Application Reference: 6/2024/1367/COND

Proposed development at: 29 Broadwater Road Welwyn Garden City Hertfordshire
AL7 3BQ

Proposal: Submission of details pursuant of condition 11 and 34 (refuse and recycling) on planning permission 6/2019/3024/MAJ

**1 External Bin Store 1 - Core B**  
 1 : 50

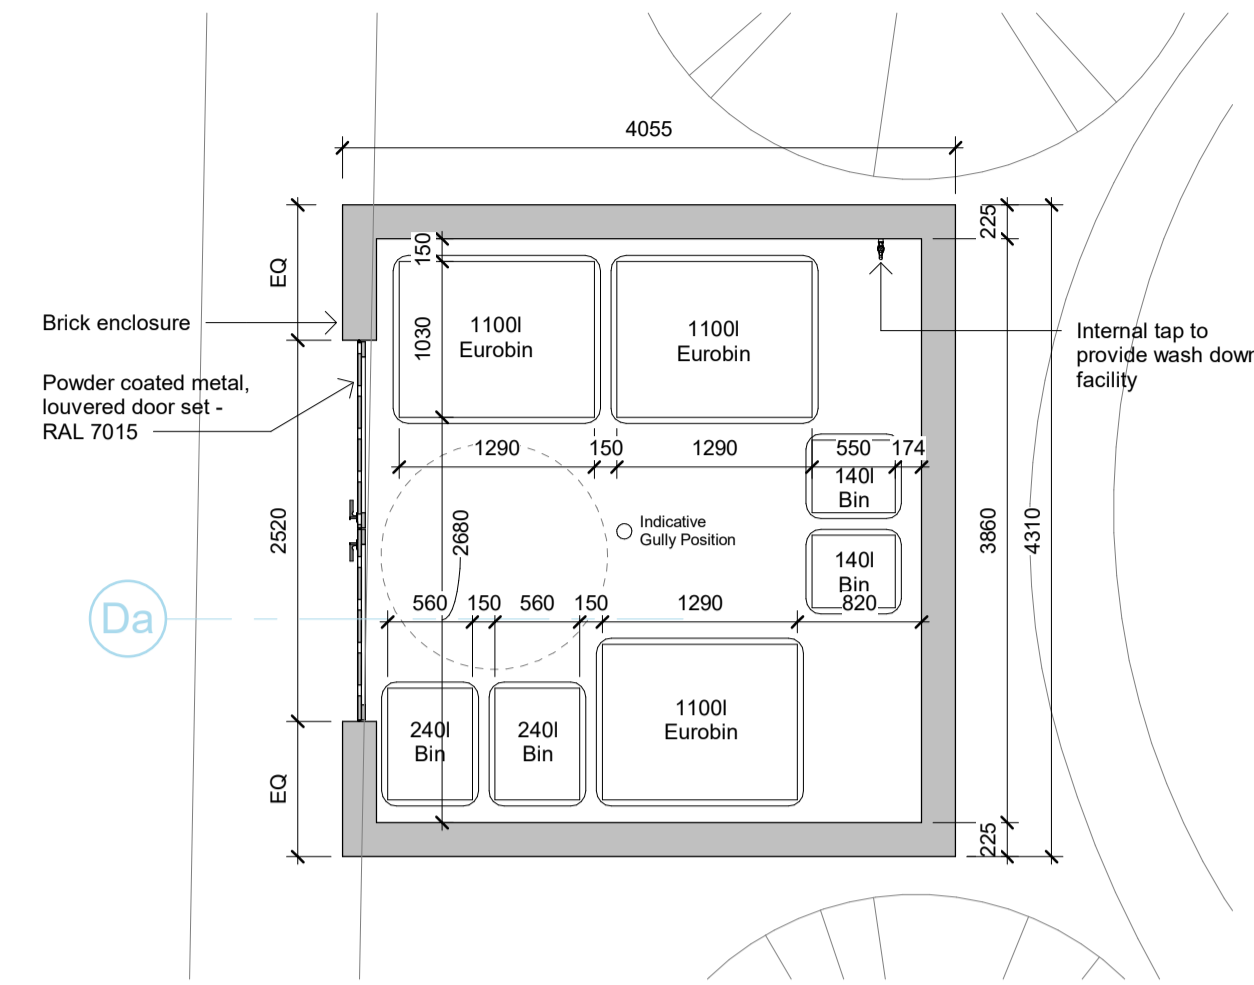
An email submitted by the agent with additional information was received on the 30/7/2024. The submitted plans replicate those submitted under this condition application. The only change to the plans is to the number of bins within external bin store 1- Core B.

Furthermore, the variation to the refuse strategy from the original submission to include external bins could not be approved under this discharge of condition. This is because external bins were not considered as part of the assessment under the original submission (6/2019/3024/MAJ) and a variation to the original application would be required to allow full assessment of the amendments to the original refuse strategy.

**3 External Bin Store 3 - Core G**  
 1 : 50

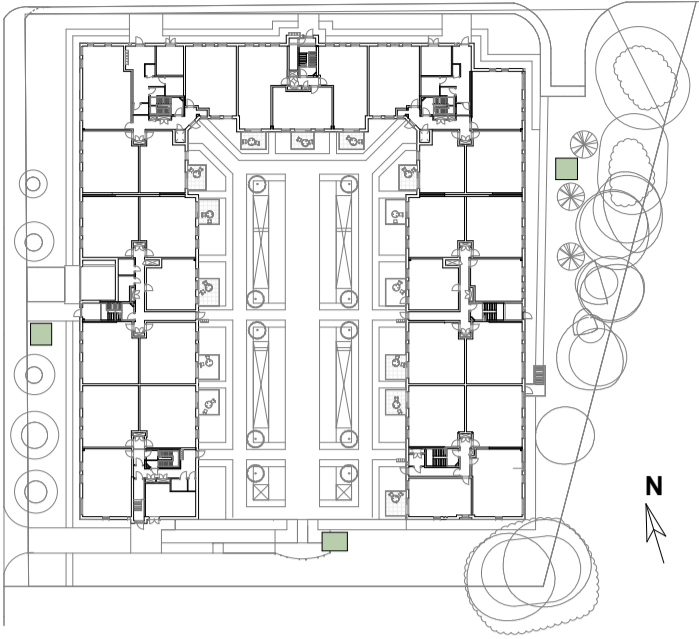
The refuse strategy varies considerably from the original submission which showed 3 bin stores. Please provide an accommodation schedule that advises how many of each type of flat (i.e. how many 1 beds, 2 beds, 3 beds etc) share each bin store so I can ensure that the calculations for receptacles is correct, the diagram shows a selection of bin sizes in the different stores and I need to advise exactly what you need for each for waste, recycling & food. In addition Bins store G is in excess of the 15m maximum drag distance allowed from store to freighter so would need reviewing.

On review of the information submitted against planning permission 6/2019/3024/MAJ, it is considered that the plans submitted do not overcome the original concerns raised by Client Services in regard to drag distance of bins.
